Application no: H06/0300/09

Description: Details of trees, existing and proposed site levels,
meter boxes, chimney, eaves and verges,
windows, external materials and hard surfacing,
tree planting and boundary treatments (Conditions :

Location: 'The Homestead Nursery' Hallgate
Gedney

Amendment: Updated window details, elevations and doors

Drawing Number:	Rev:
A0760-21	A

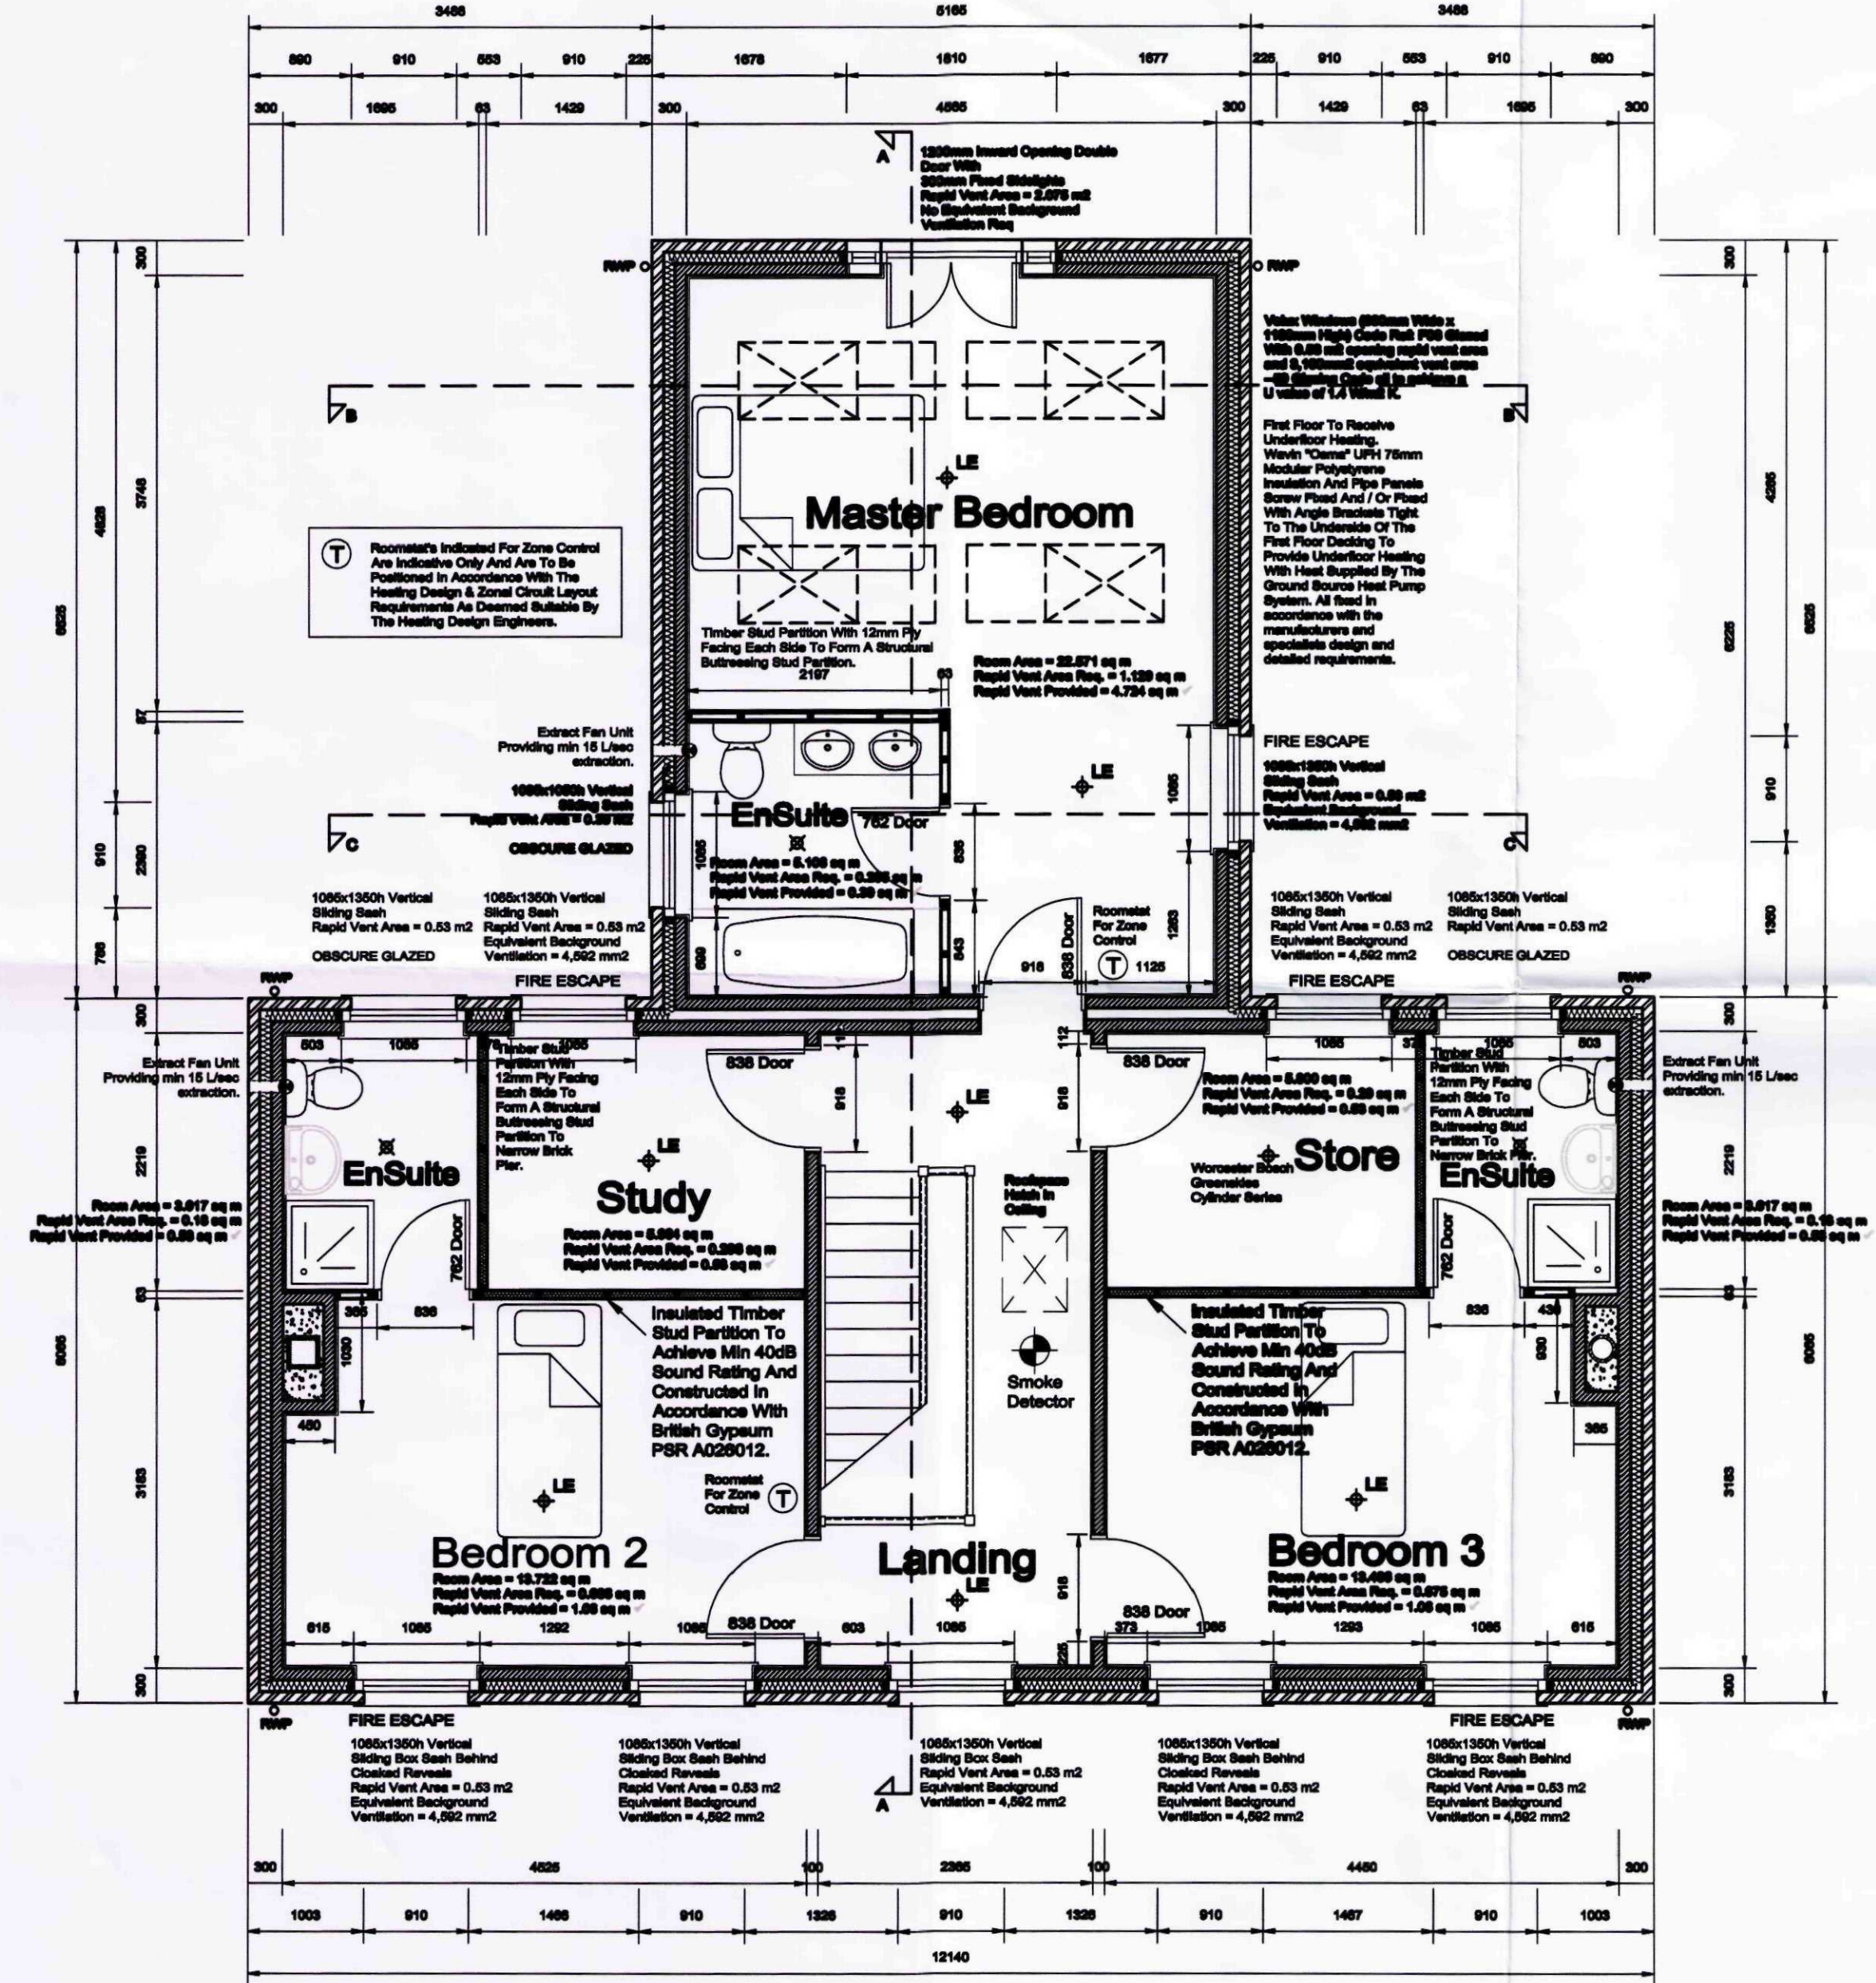
As discussed last week we have some updated window details which are to replace those sent to you previously for the discharge of the Conditions on the above scheme. Attached are the main plans and elev drawings indicating the door proposals as well as the window proposals. A detailed window drawing is in a separate email.

You will also note that on the updated plans and elevations which now detail all the opening sizes also includes the relevant door references proposed for the garage doors and dwelling entrance doors. Attached are two emailed proposals for the doors.

A0760-22

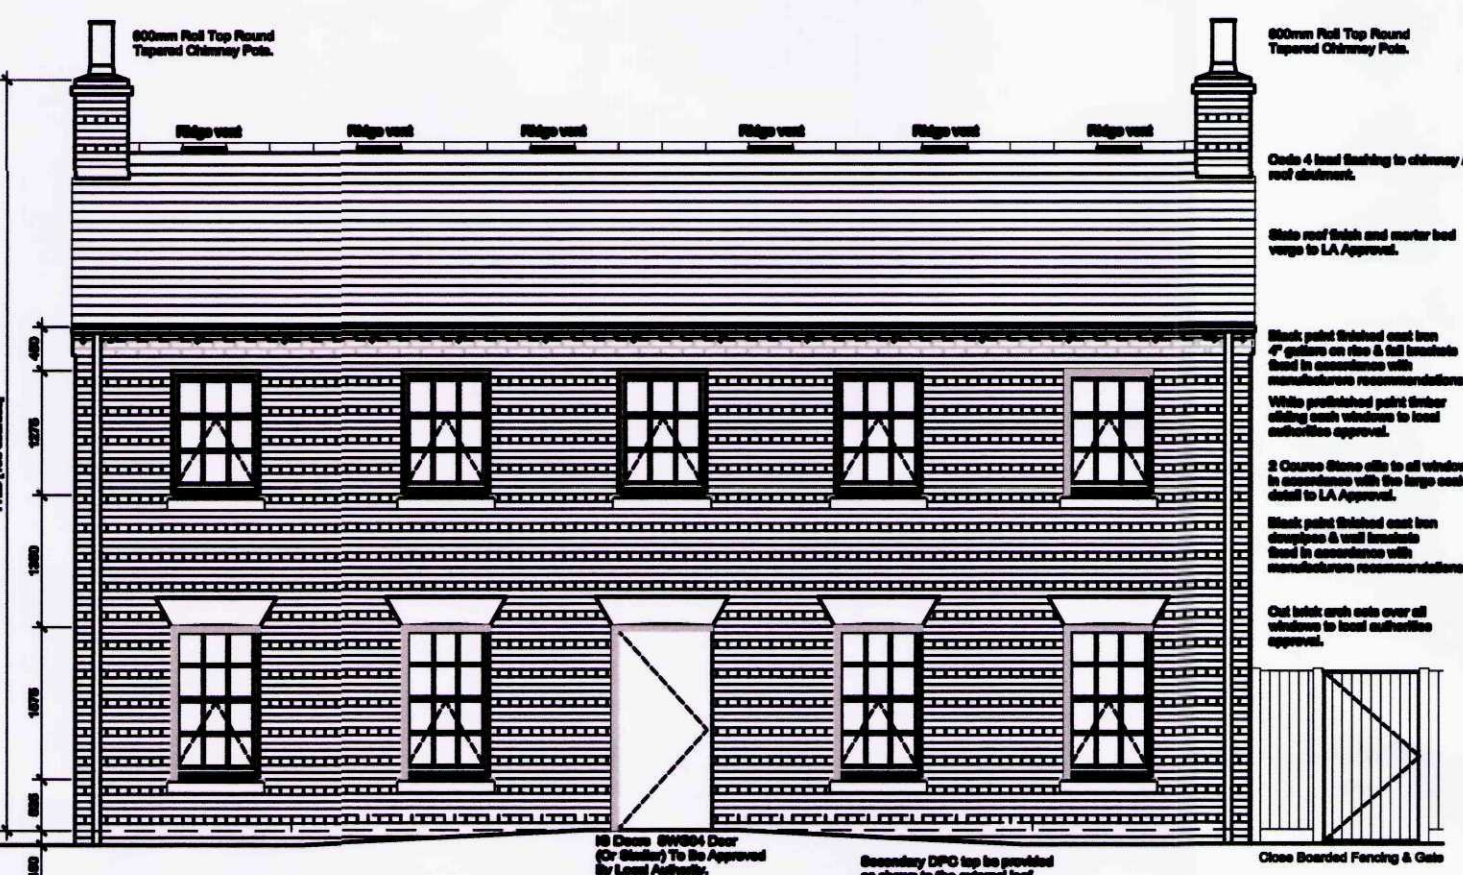
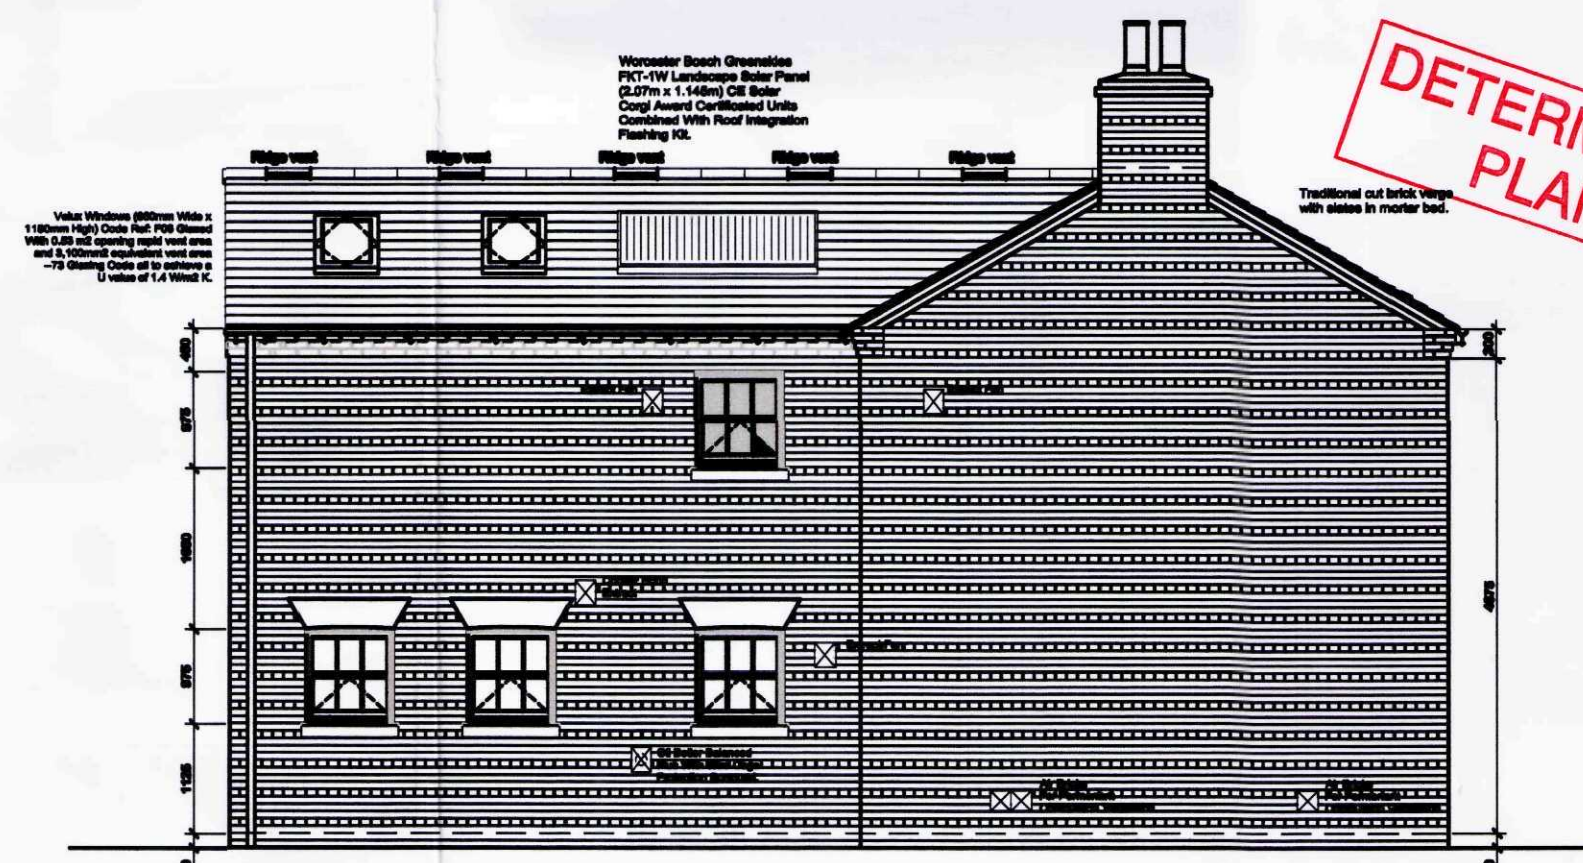
Main dwelling entrance doors = IG Doors – Steel Wood grain effect Style SWG04
 Garage Doors = Garador Seymour
